Subject: Planning Comment (Objection) Re: FG/14/22/PL 9 Ocean Parade Ferringham Lane Ferring BN12 5QG

Application FG/14/22/PL follows a submission for prior approval for change of use of commercial (retail) units to residential (FG/206/21/PD).

This current application to "Replace existing shop front to ground floor front elevation with new door and windows....." makes no reference to the intended future purpose of the site which it refers to as 'retail'.

Drawing
Proposed Plans.

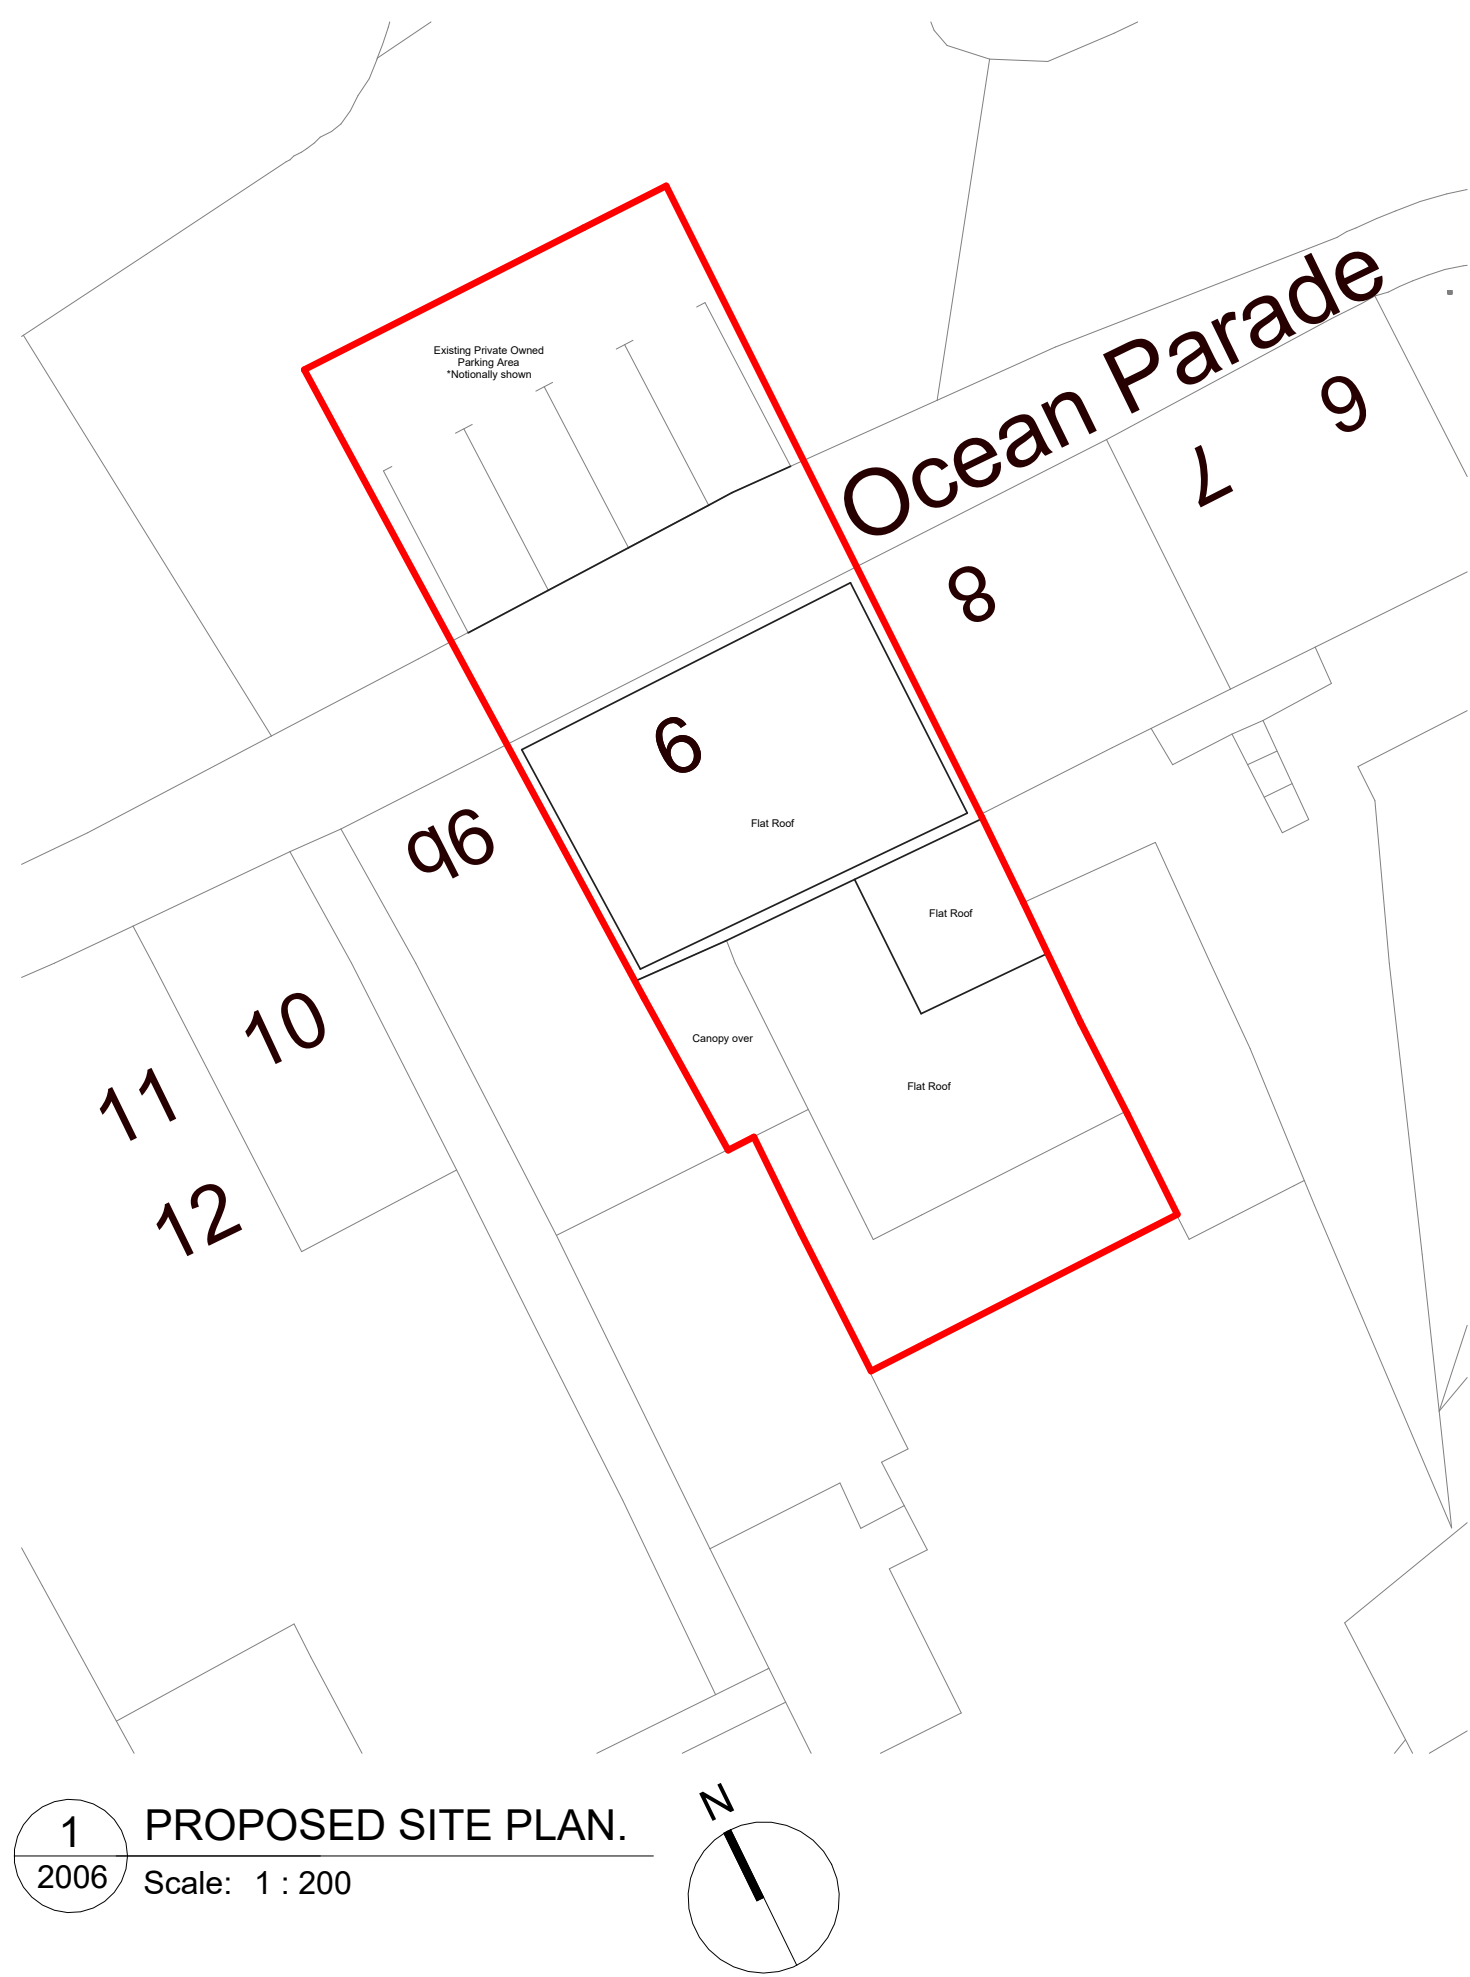
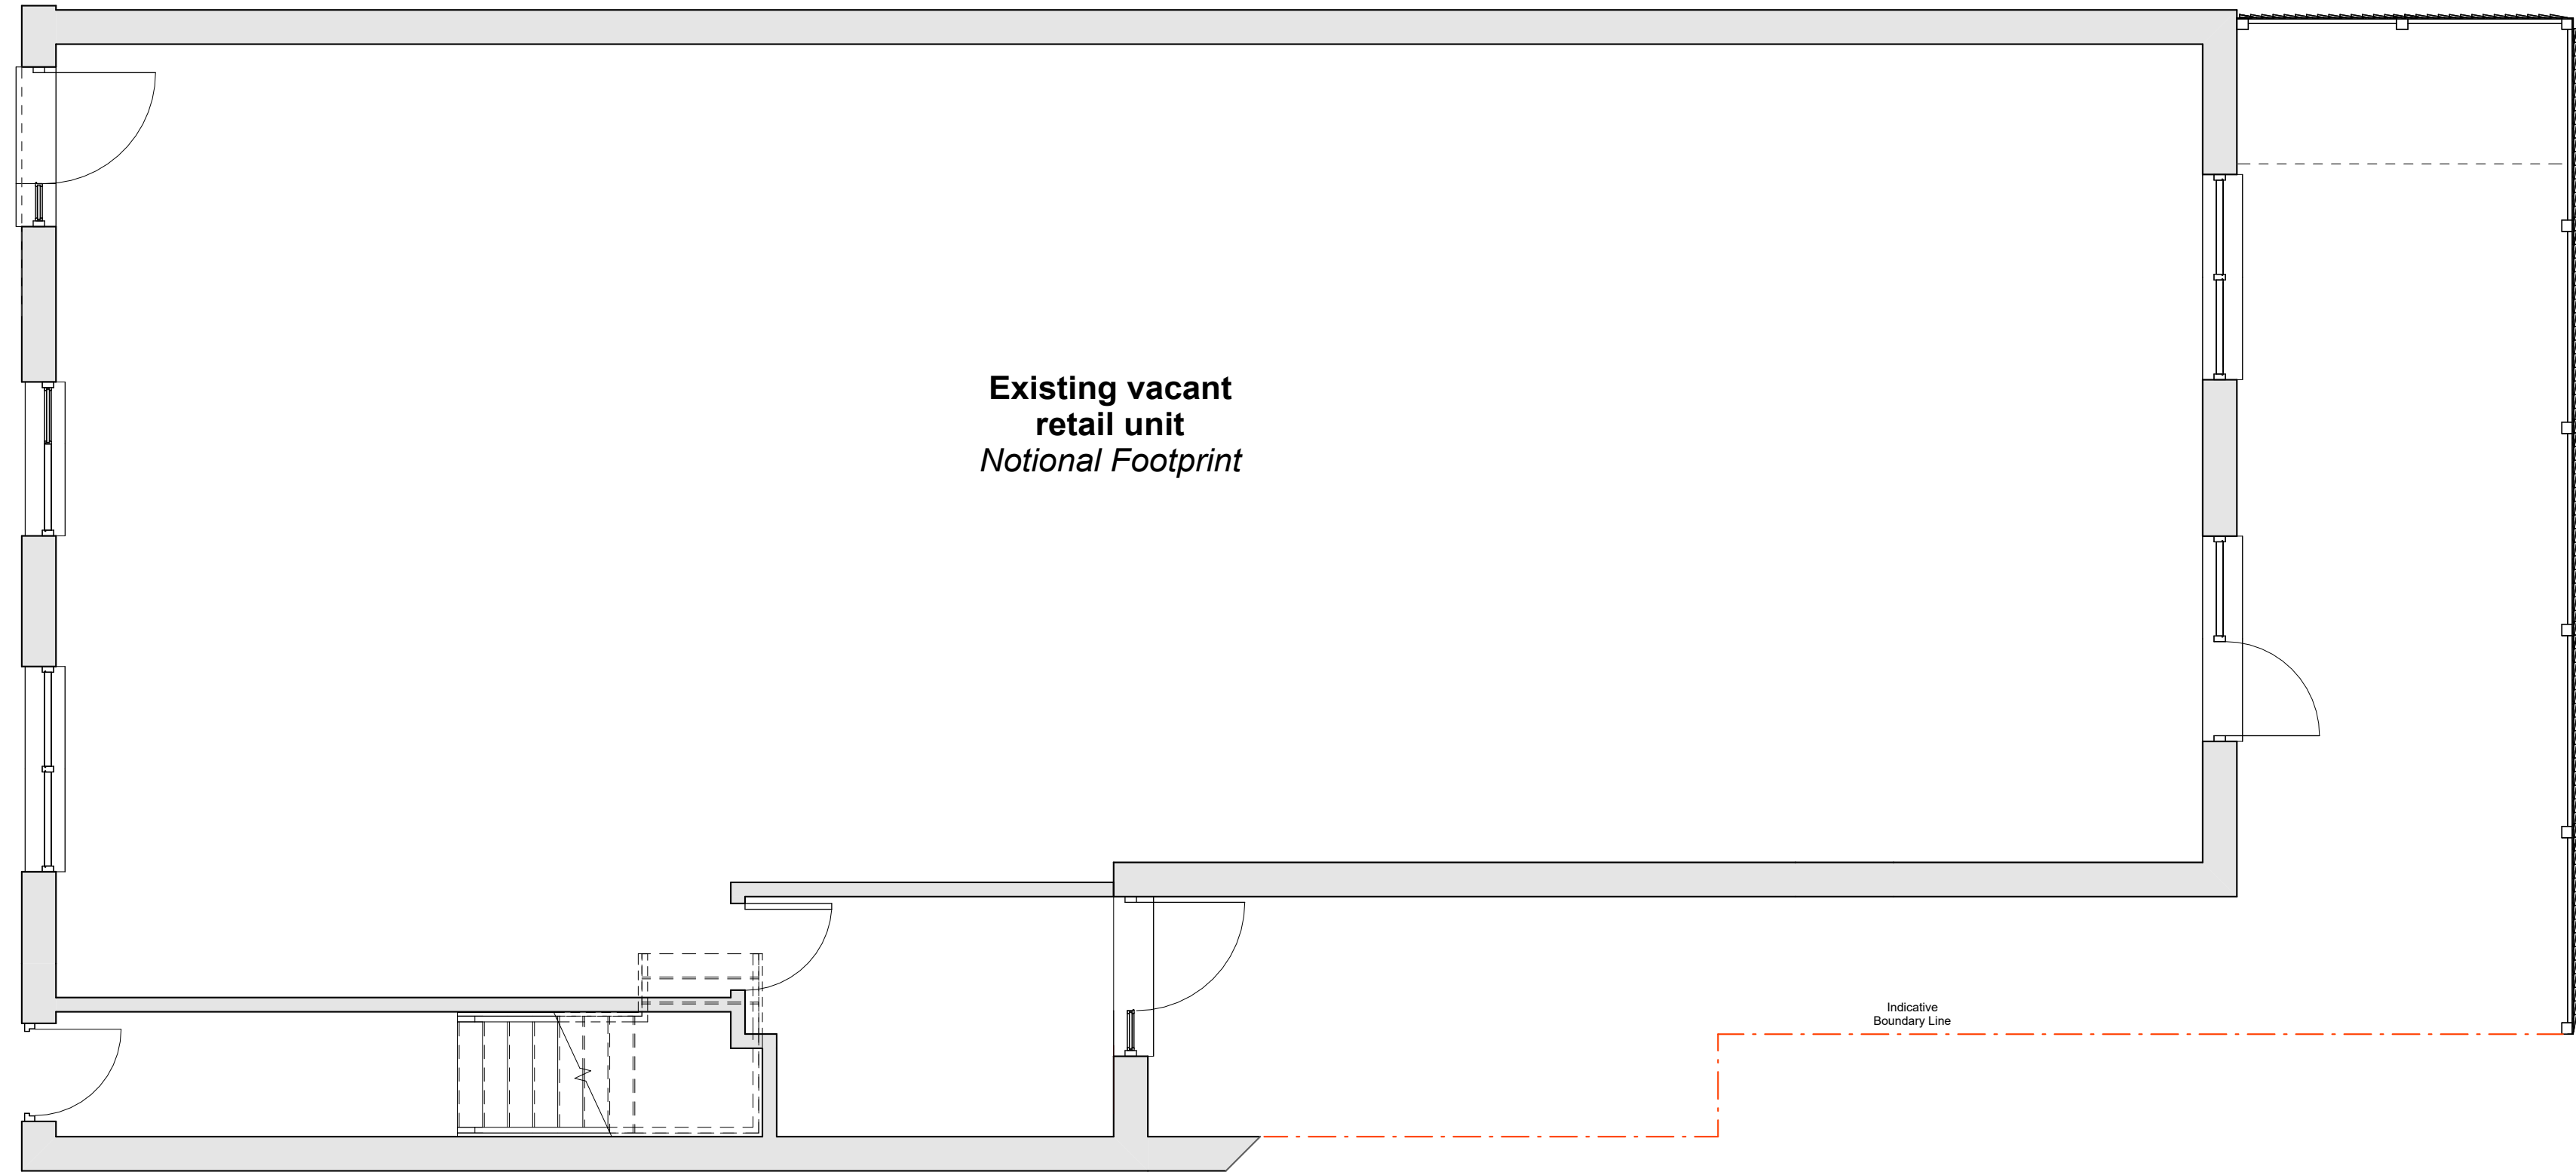
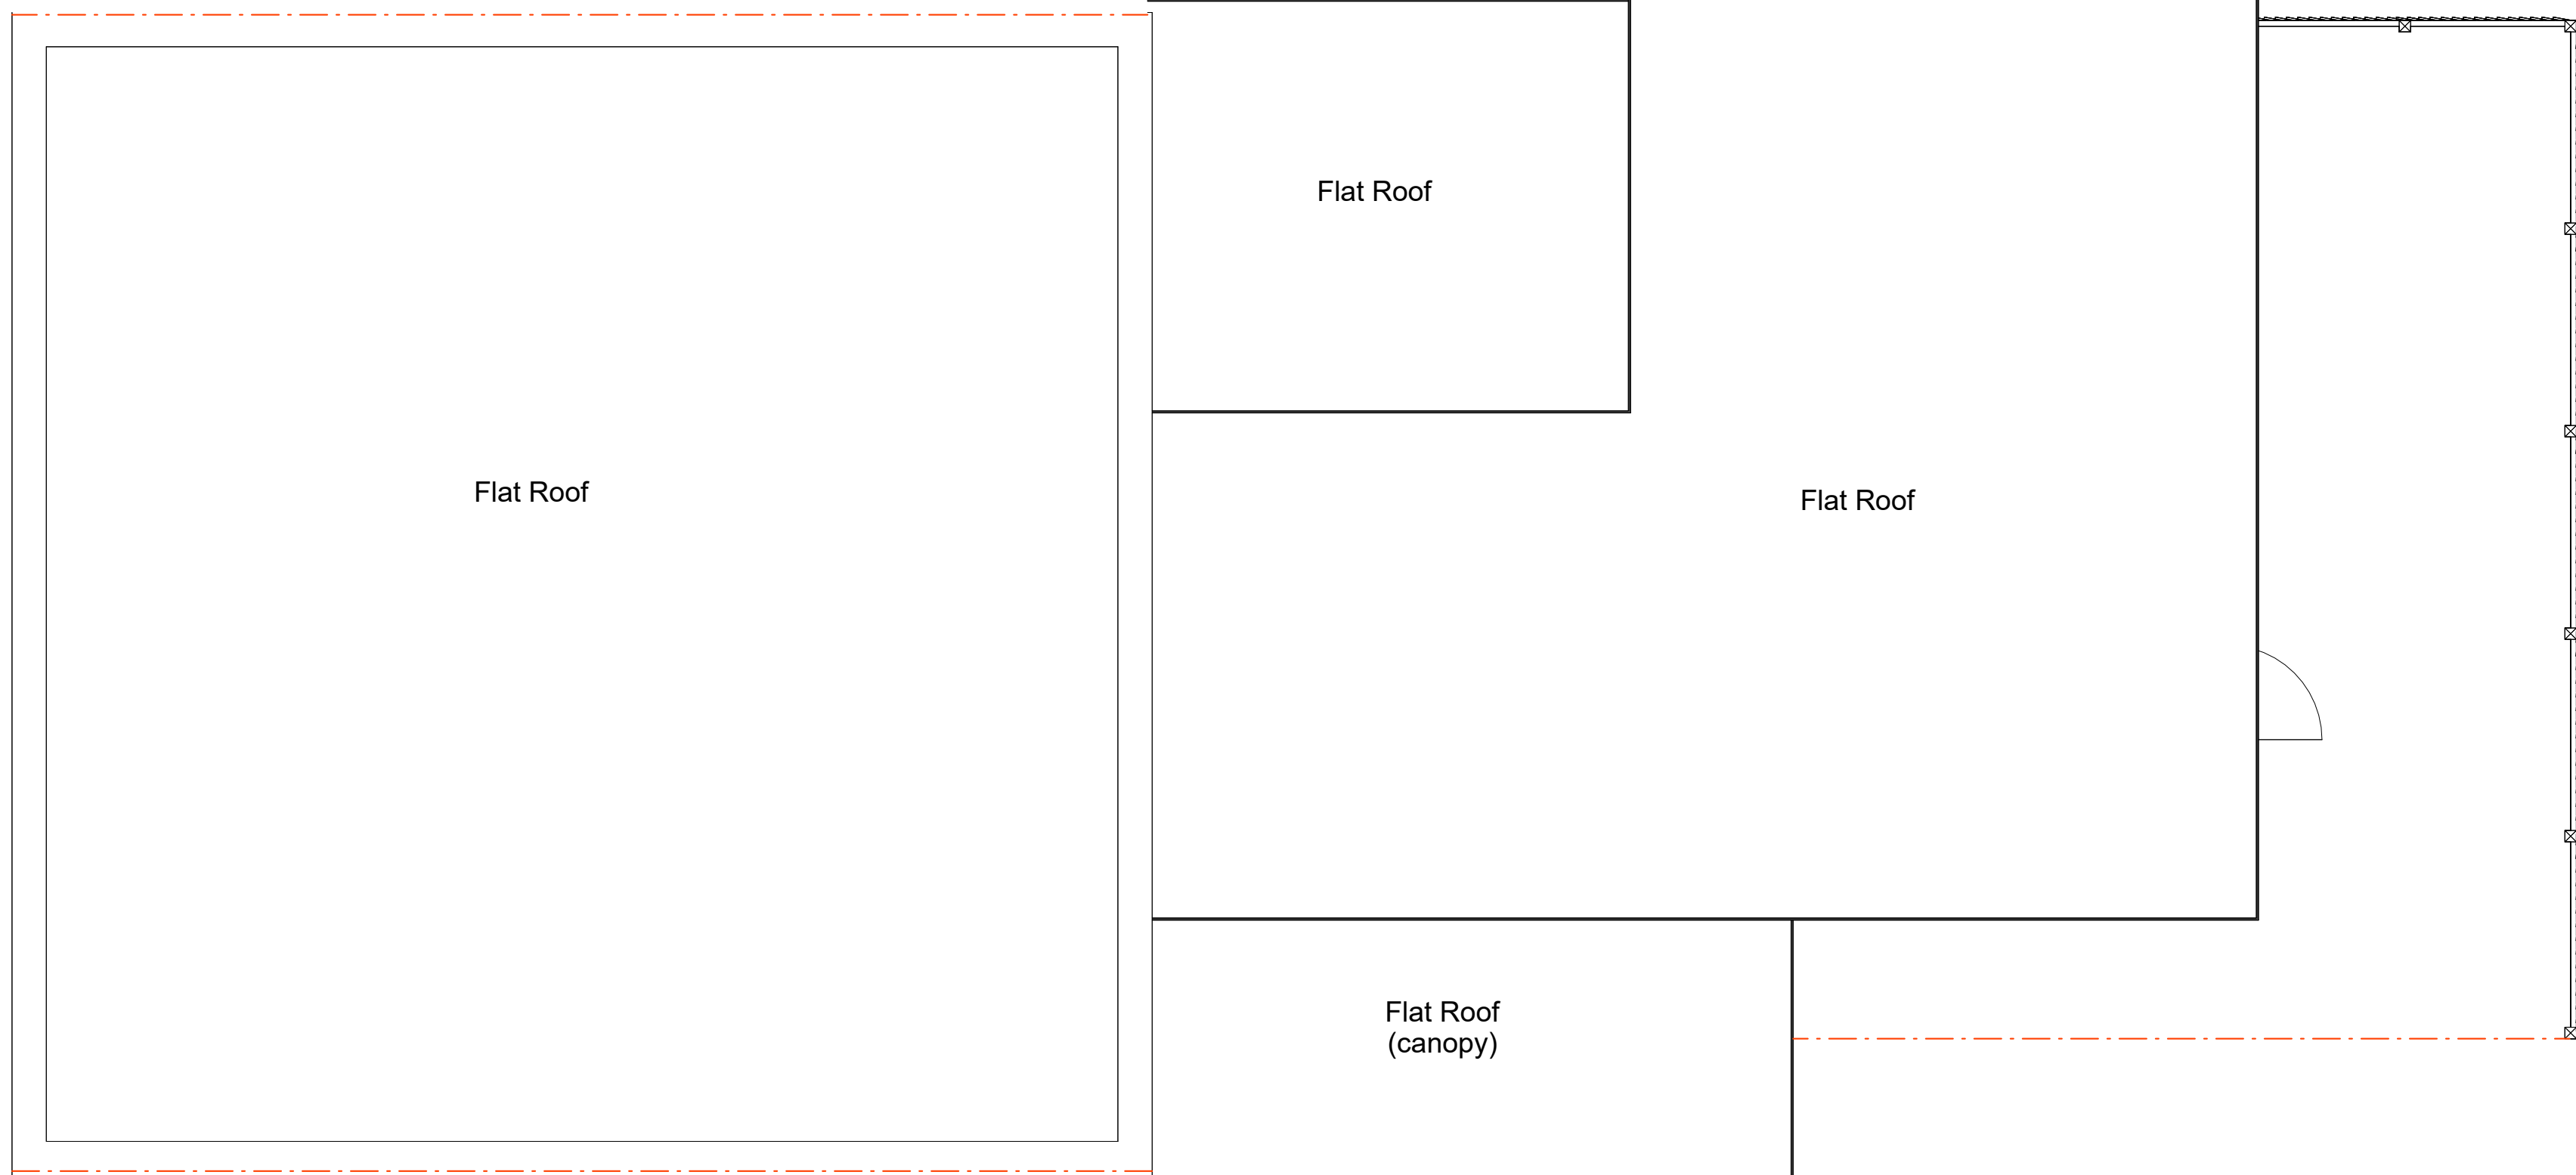
In isolation, there is no rationale for the design in this application. The proposed exterior design would not be in keeping with retail units and no floor plans for sub divided retail have been provided. The Parish Council would therefore object on the basis that the proposed redesign is not commensurate with its ongoing retail use and is out of keeping with other units in the immediate area.

In summary, Ferring Parish Council objects to this application (FG/14/22/PL) as it would be unsympathetic / unsuitable for continued retail use, out of keeping and failing to provide corresponding interior design detail.
